due to the lack of information provided, Engineering reserves the right to make additional comments. A full review was not performed on this plan.

GRADING AND EROSION CONTROL PLAN
APPALOOSA HIGHWAY 24 SUBDIVISION FILING NO. 2
EL PASO COUNTY, COLORADO

Subject: Engineer
Page Label: 2
Author: dsdnijkamp
Date: 8/17/2018 10:40:48 AM
Color:

GRADING AND EROSION CONTROL PLAN
APPALOOSA HIGHWAY 24 SUBDIVISION FILING NO. 2
EL PASO COUNTY, COLORADO

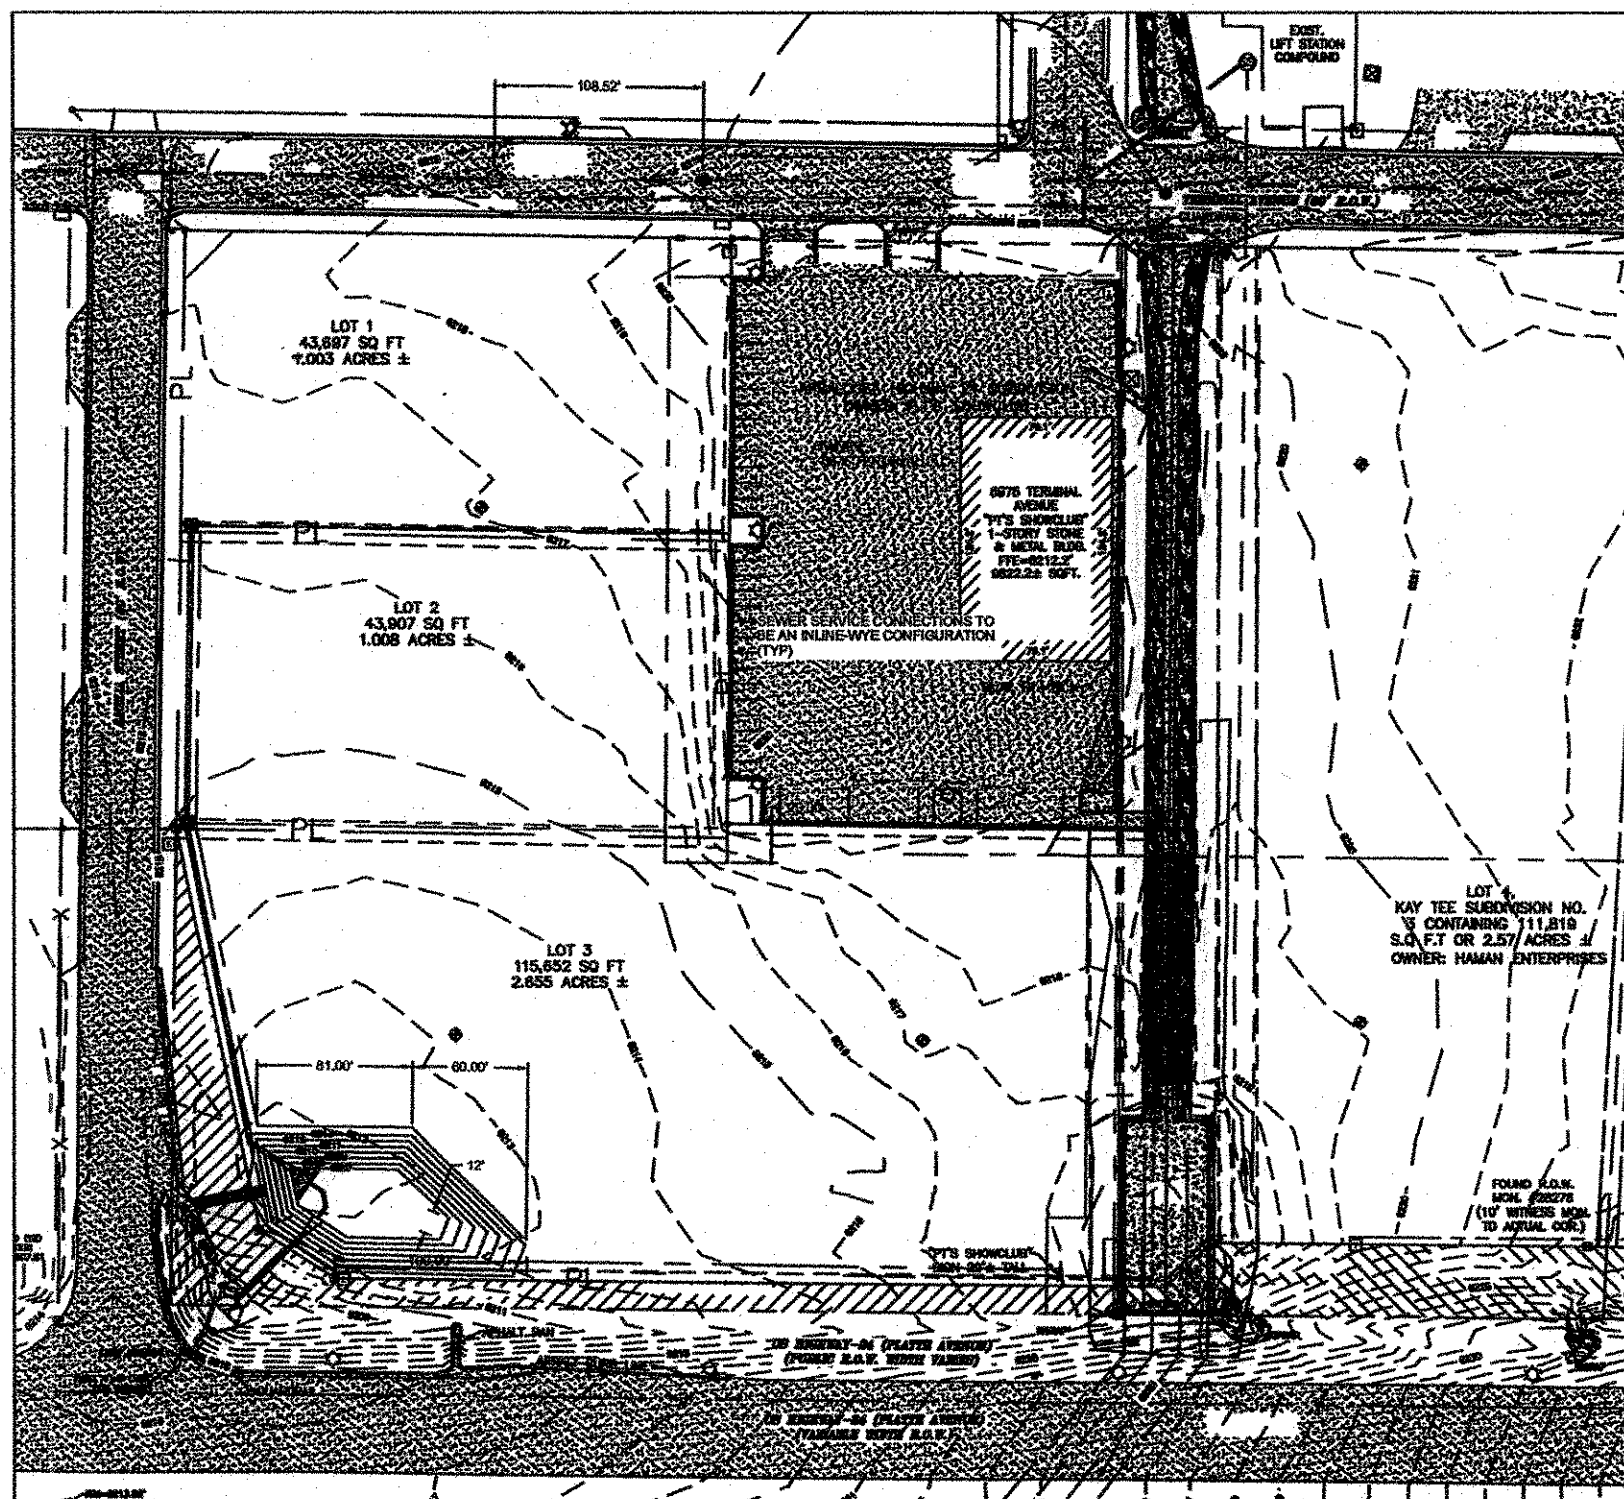
Please change all references of DSD to PCD.

Please clearly show the property lines and all existing and proposed easements. I do not see any construction BMP's shown at this time, no VTC, no CW.

OUTLET STRUCTURES DETAILS
NOT TO SCALE

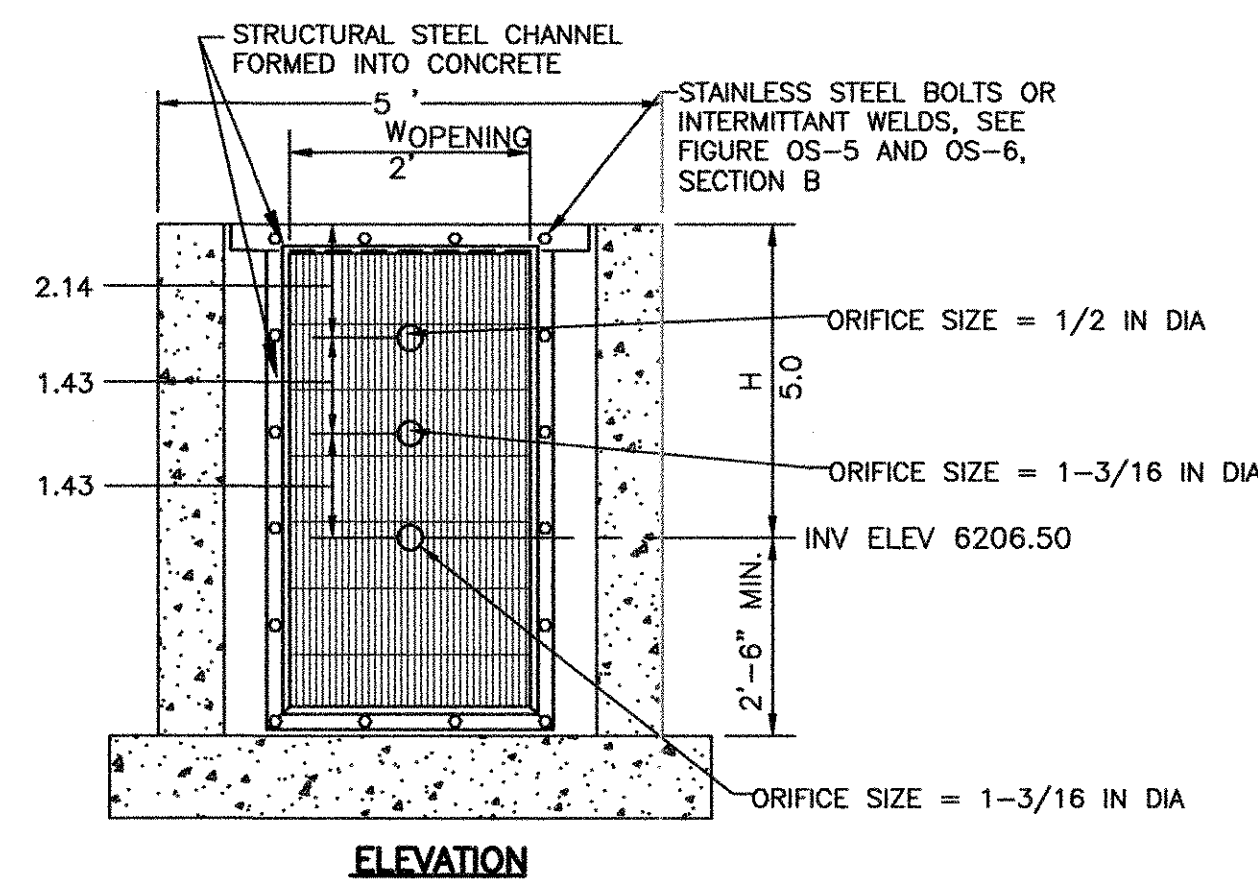
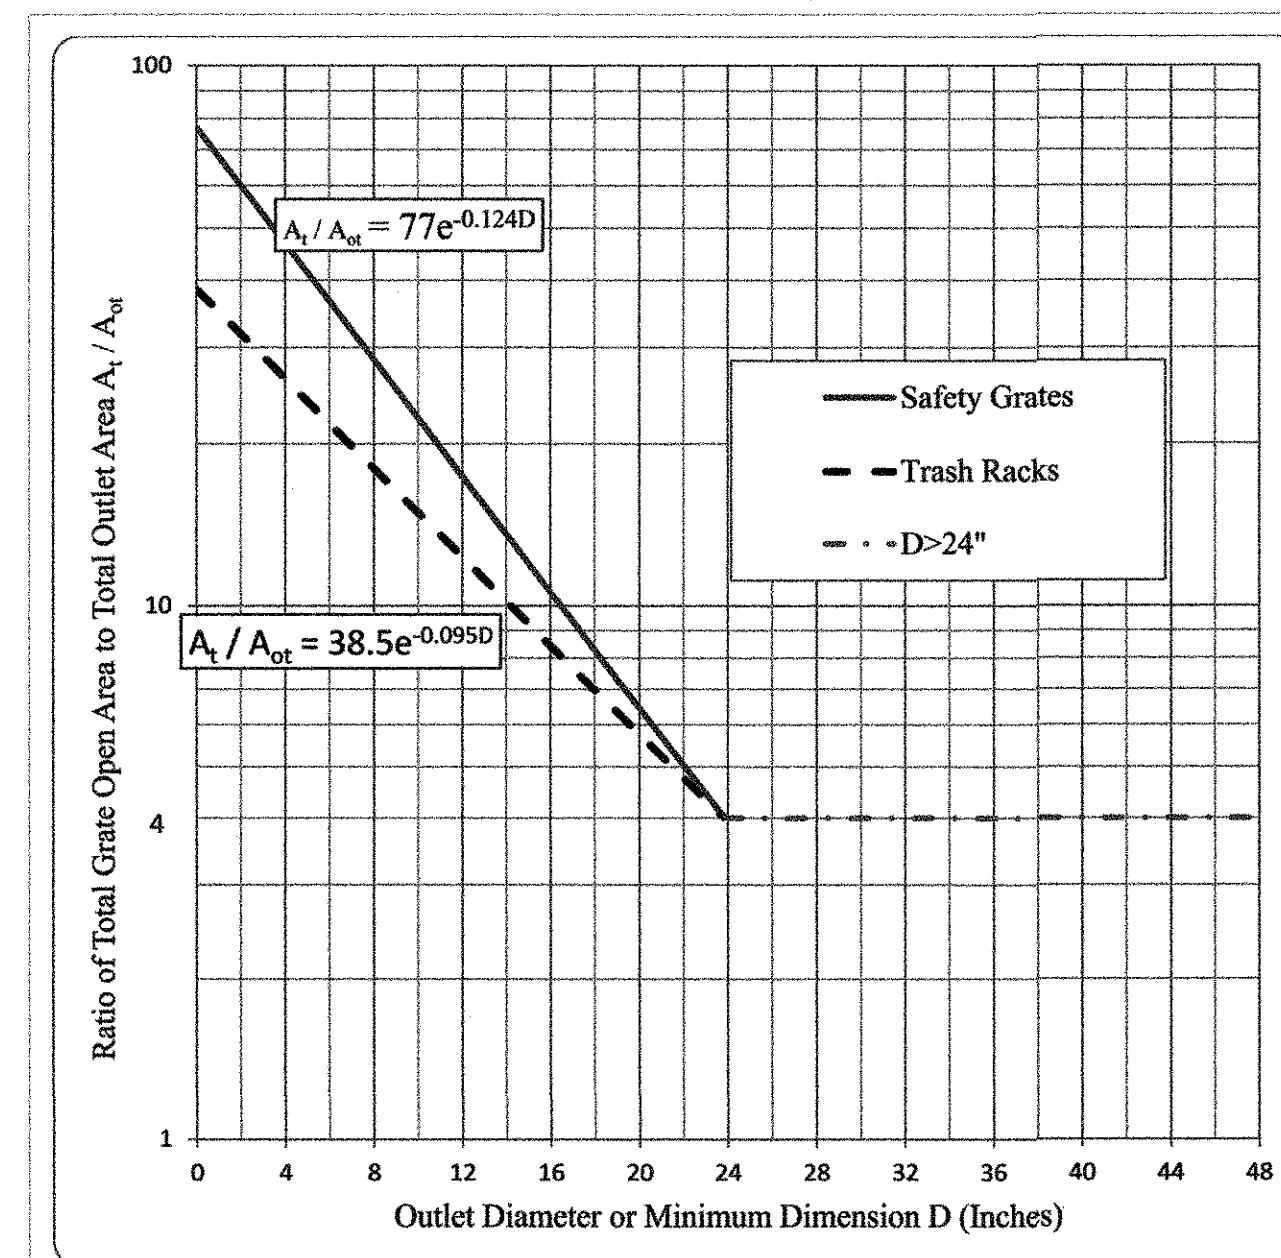
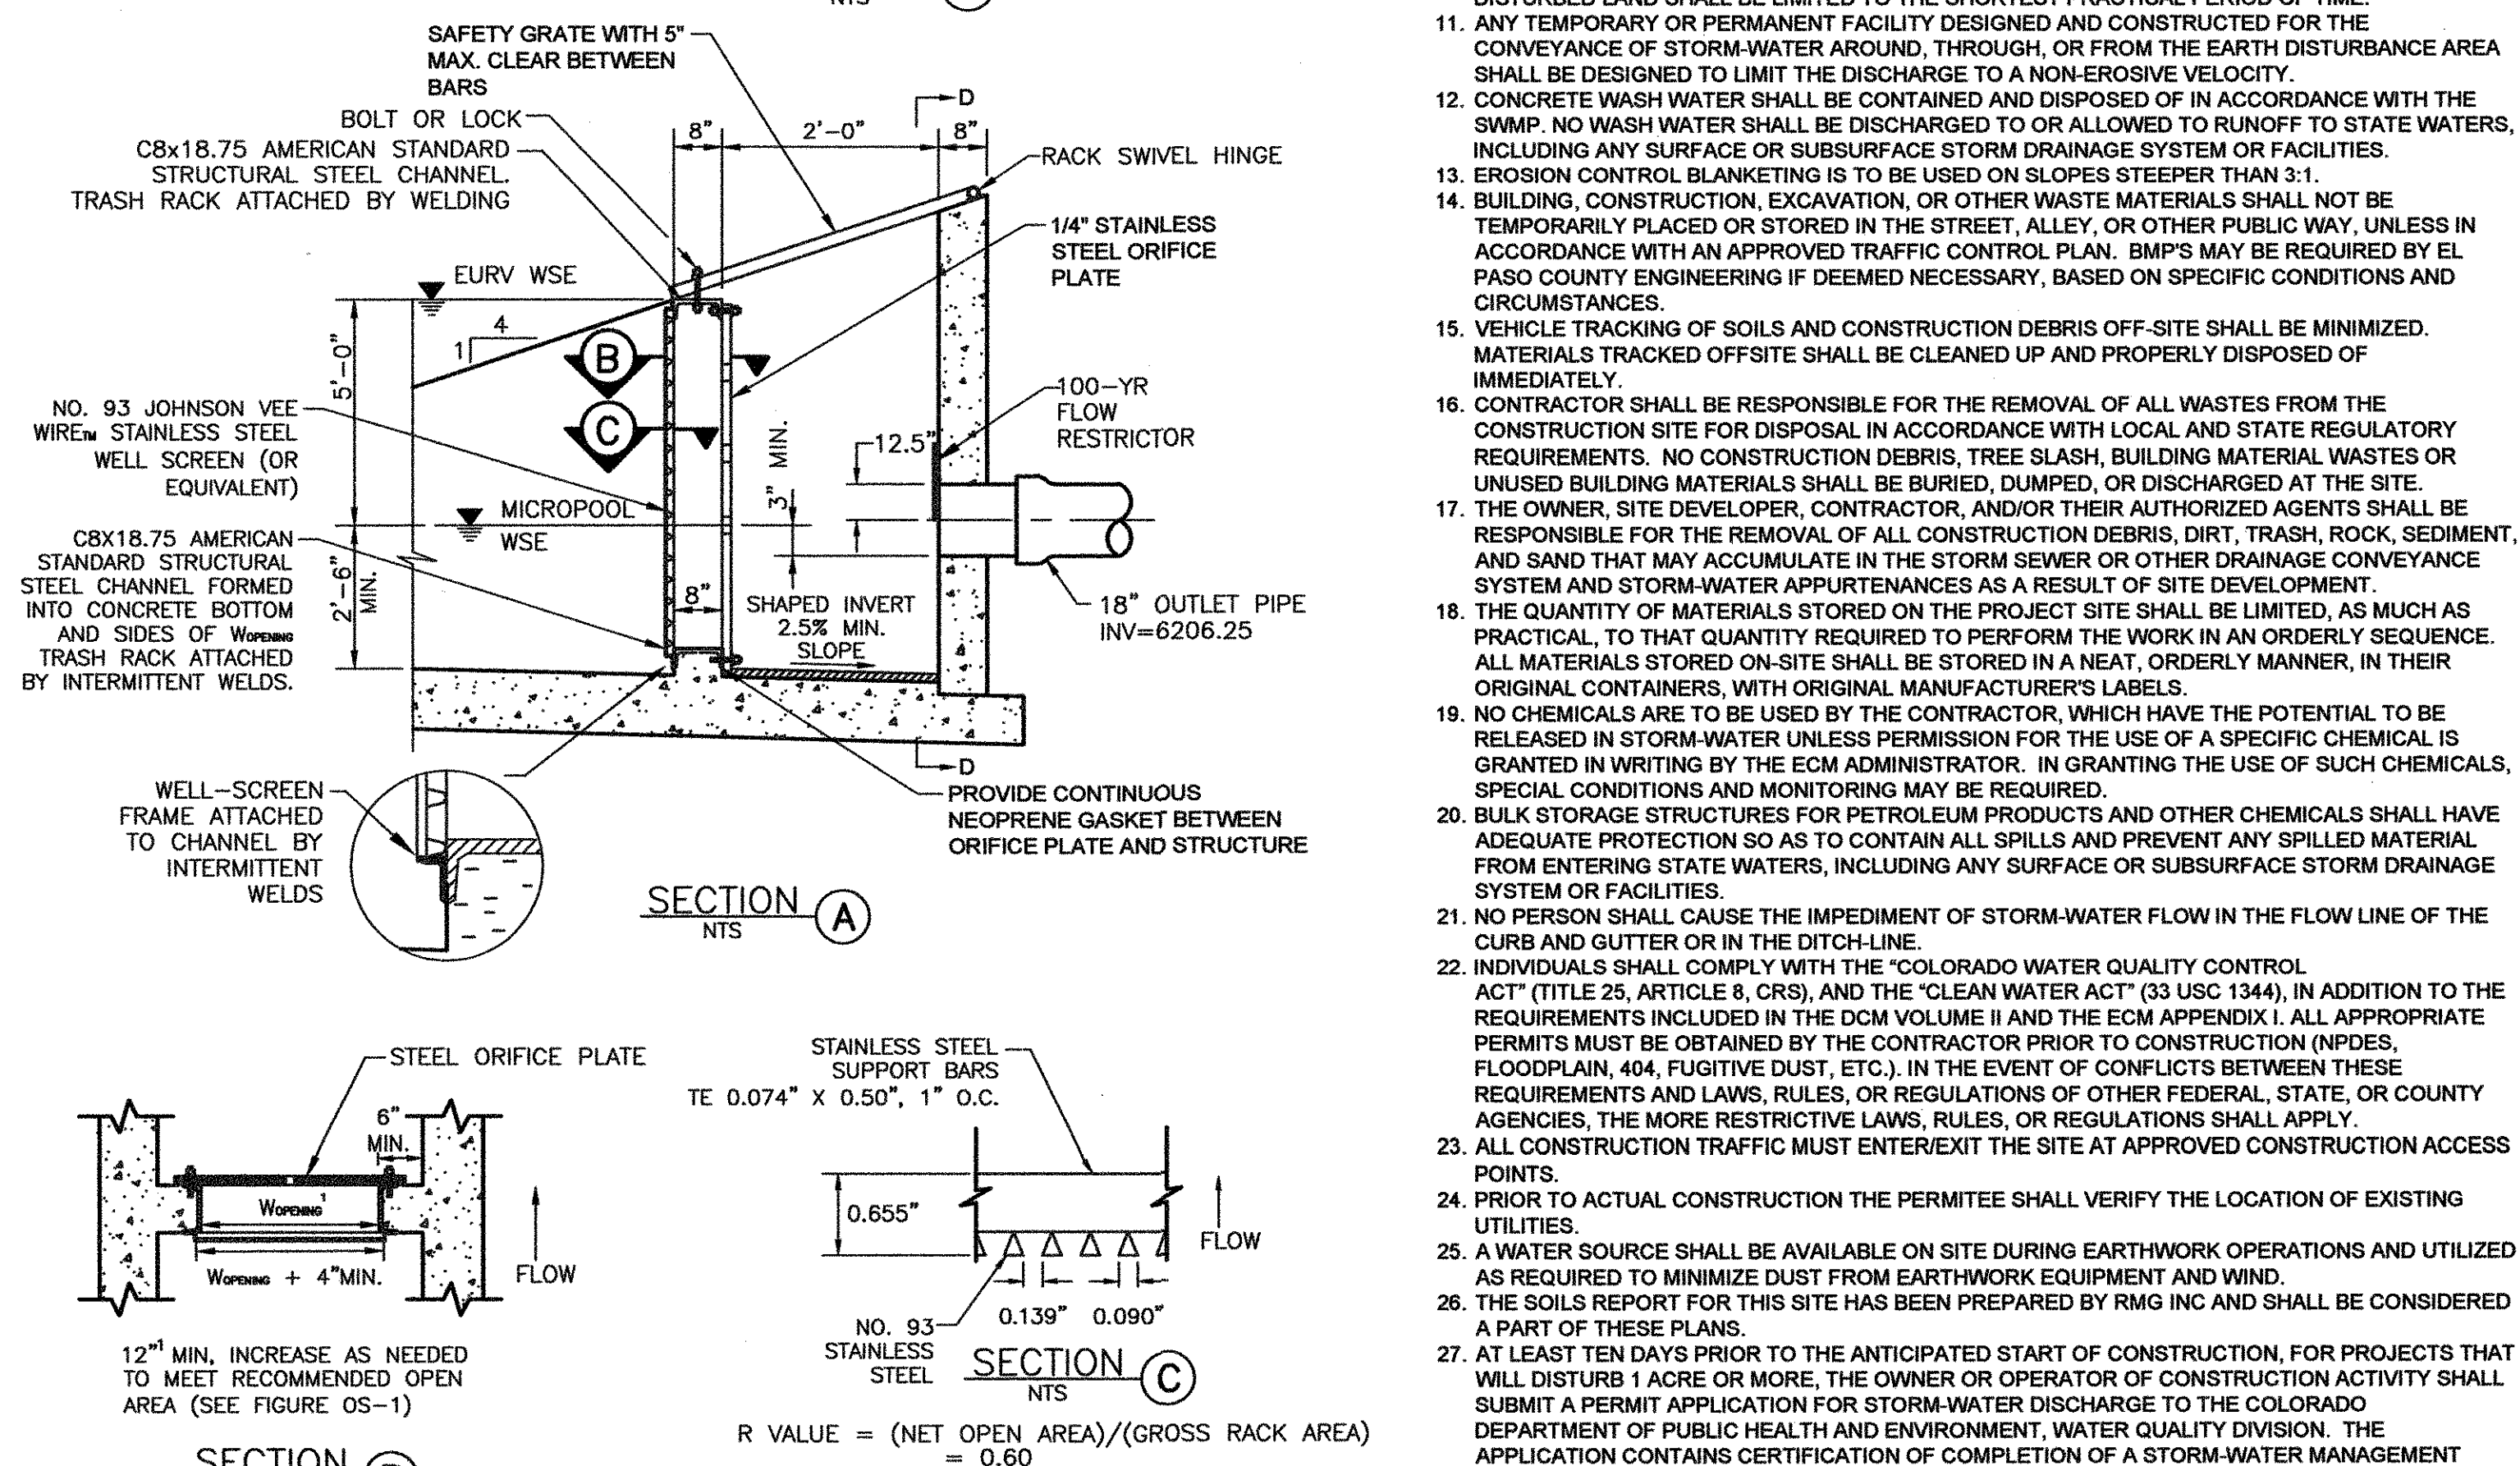
Not enough information provided to perform a review. what size is the holes in the orifice plat, how does the forbay connect to the in coming water's pipe (FES), etc?

ORIFICE SIZE = 10.31 Sq IN
(TYP)
